Saffron Lodge
46 Kingsway, PO21 4DN
My Ref: AW/85/18/HH-2

Ref: **OBJECTION : AW/85/18/HH (54 Kingsway, Craigweil) Substitute Documents**

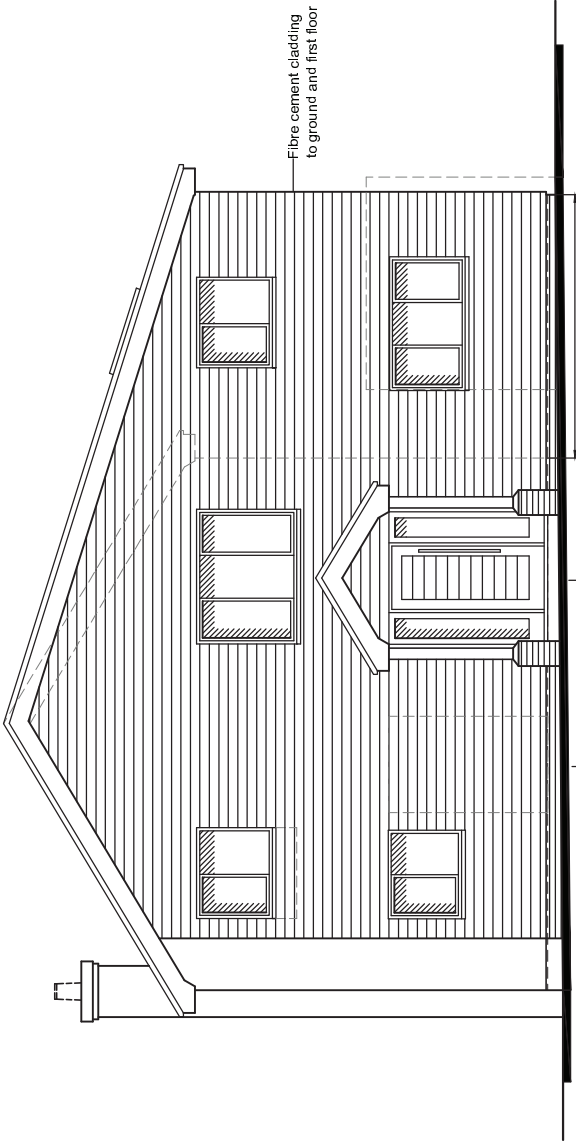
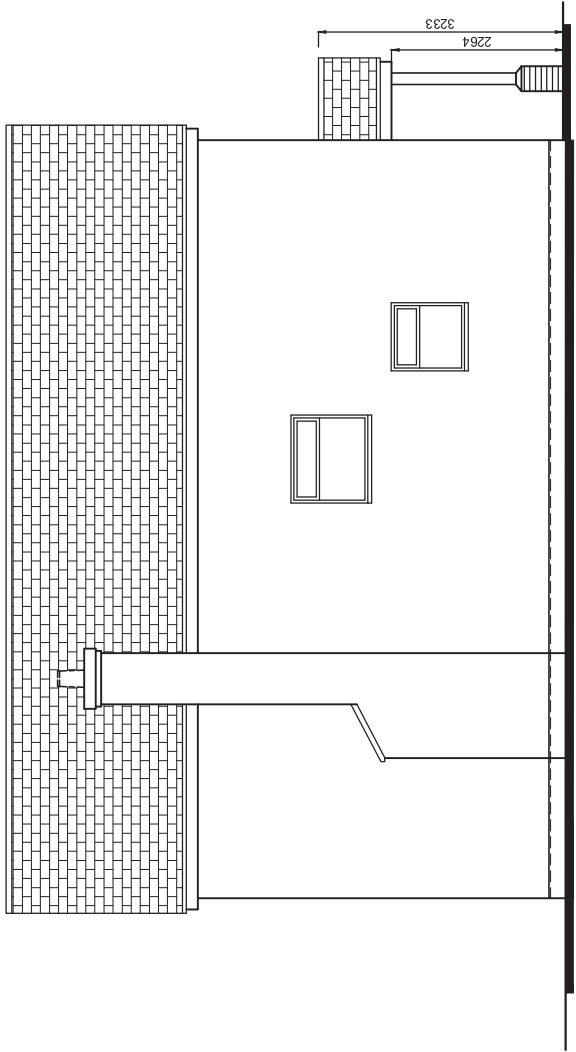
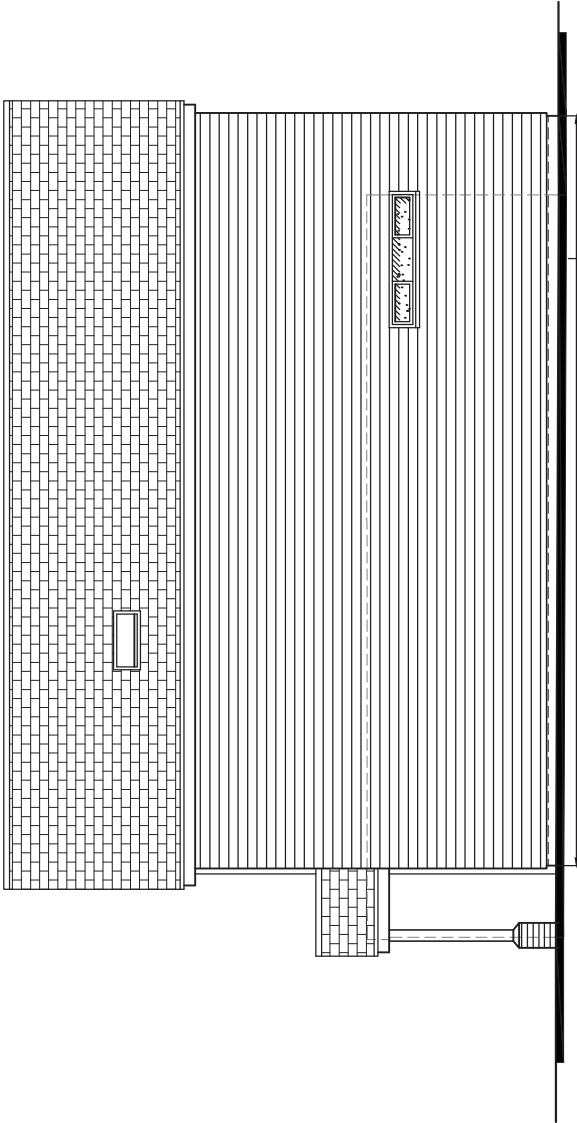
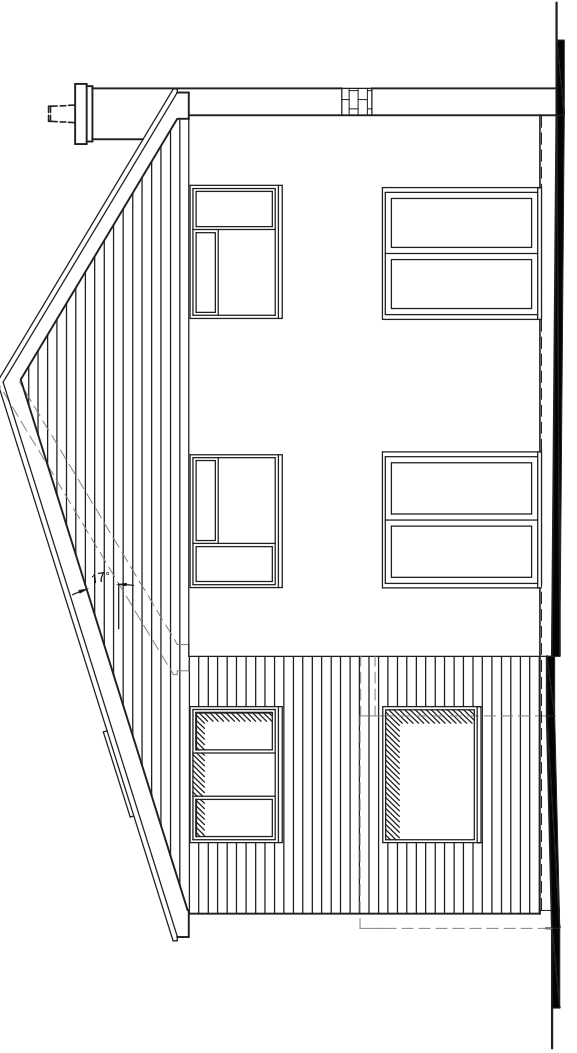
surrounding environment' (13.2.6) **Again clearly, these proposals have a considerable and unacceptable impact in the immediate area.** All surrounding properties will have a very different outlook to that which exists, reducing the relatively open aspect, into a closed effect with the large infill over the replaced ground floor garage space.

6. **HER DM3f concerns 'harming important views into, out of or within the Conservation Area'. Clearly the appearance of the proposed design will be seen from north, east and west directions including maybe Marquis Way, and therefore **it's block like effect will have, in my opinion, a prominent and adverse effect upon the surrounding area.****

9. We still have no indication as to the colour, texture or type of cladding materials. Study of the Application gives no indication as to the colour of the proposed cladding material, even though **Question 11 specifically requires** details of '**type, colour and name of materials**' to be recorded. The only colour mentioned is Dark Grey for the roof slates, hopefully not black. The Applicant's subsequent email at least confirms the colour of the cladding to be Cream/Off White. The query on this was obviously raised due to the Agent/Architect's omission in Question 11. **But we still lack detail of what is proposed.**

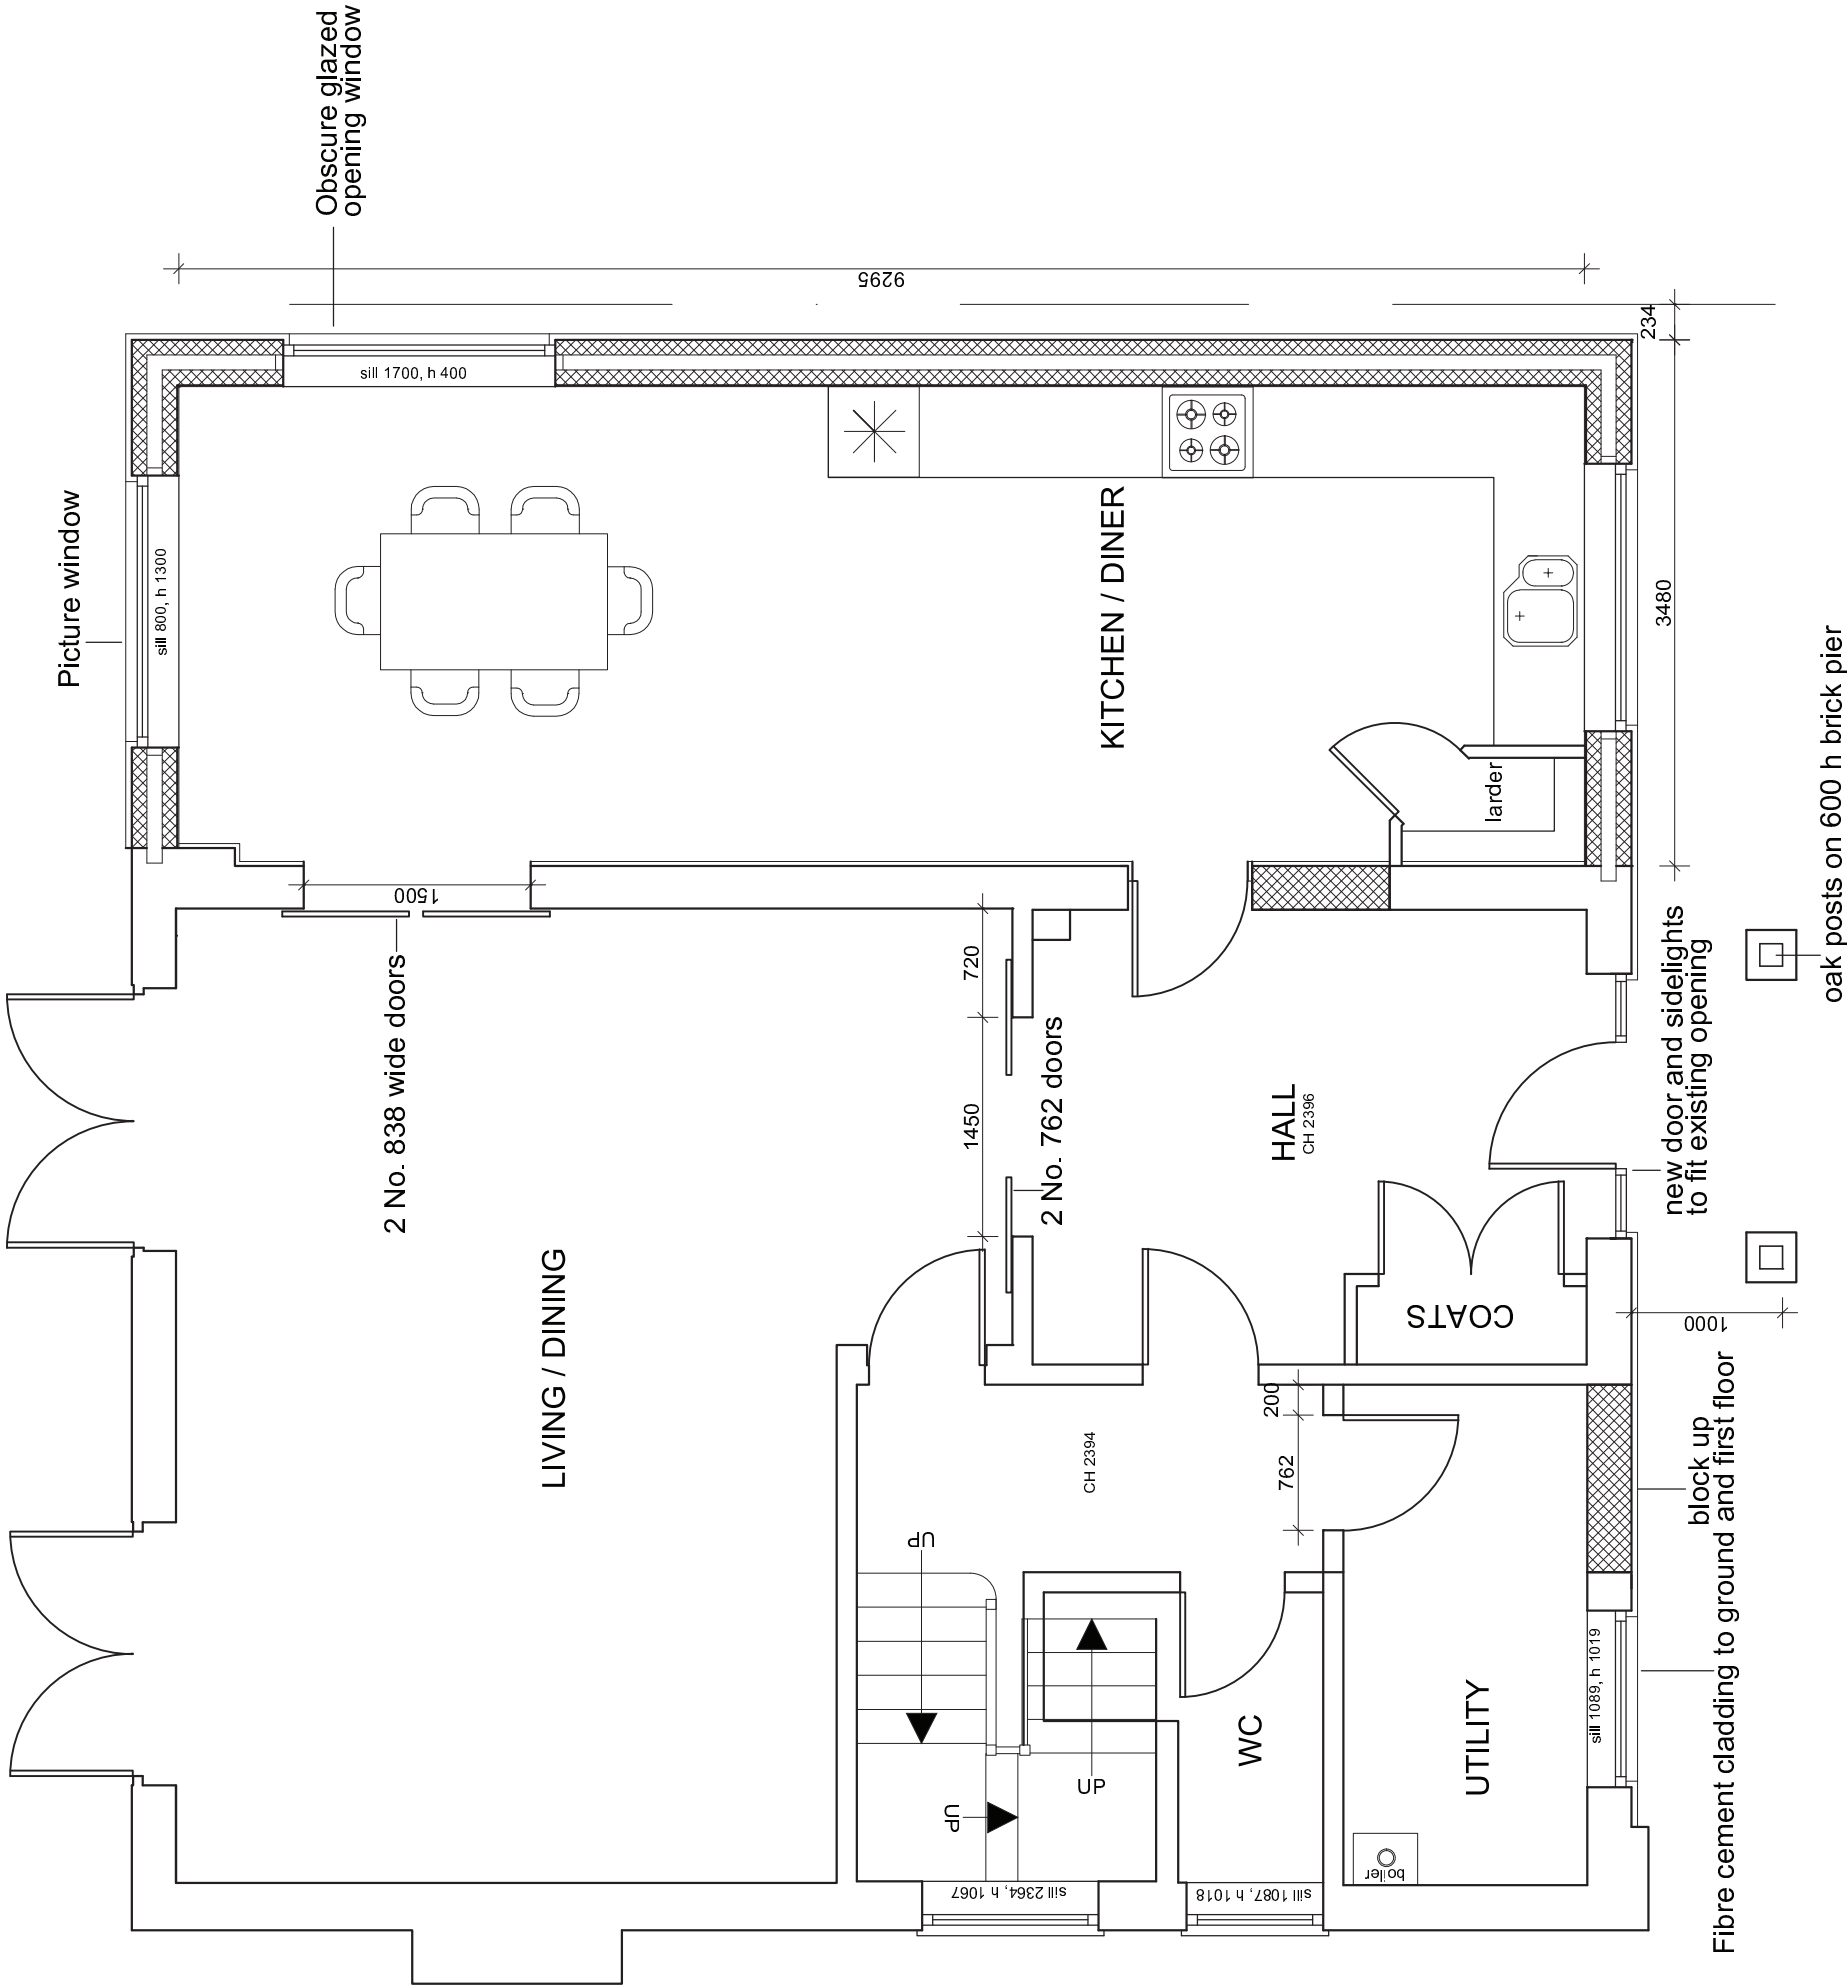
2. **Policy D SP1** in the District Plan refers to **special awareness** of surrounding buildings. So close to No 52 Kingsway and infilling the space above the garage, it is unsympathetic and compromises the space between property, contrary to the **general** street scene and pattern of development in the CHCA. The Policy states '**but reflect the characteristics of the site and local area in their layout, landscaping, density, mix, scale, massing, character, materials, finish and architectural details.**' Several of these are ignored here. '**Development proposals should have been derived from a thorough site analysis and context appraisal.**' I see none of this forthcoming.

7. Removal of the garage from the property also dictates that cars will always be on view in the front garden, a very different situation to property generally, where parking is contained within garages. Craigweil is not a 'town centre nor are other means of transport close at hand.' Residents here have cars in the main, in this case at least two. According to the **ADC Supplementary Guidance on PARKING STANDARDS**, a 4 bedroomed house requires plans to provide a total of at least **3 car parking spaces**. In this case, the cars will need to be parked within the small front garden. Families with children, this family has three, is most likely there will be more vehicle parking required in the near future. I question whether there is enough space for three parked cars in the small front garden and turning space is out of the question. Permanent parking will therefore be on view 24 hours in the day. The likelihood of street parking then comes into play, especially with no garage on site. Street parking in Kingsway is discouraged by the Estate Management and residents abide by that norm now. Any erosion of that 'norm' will create a precedent. Such conditions should not prevail in a Conservation Area.
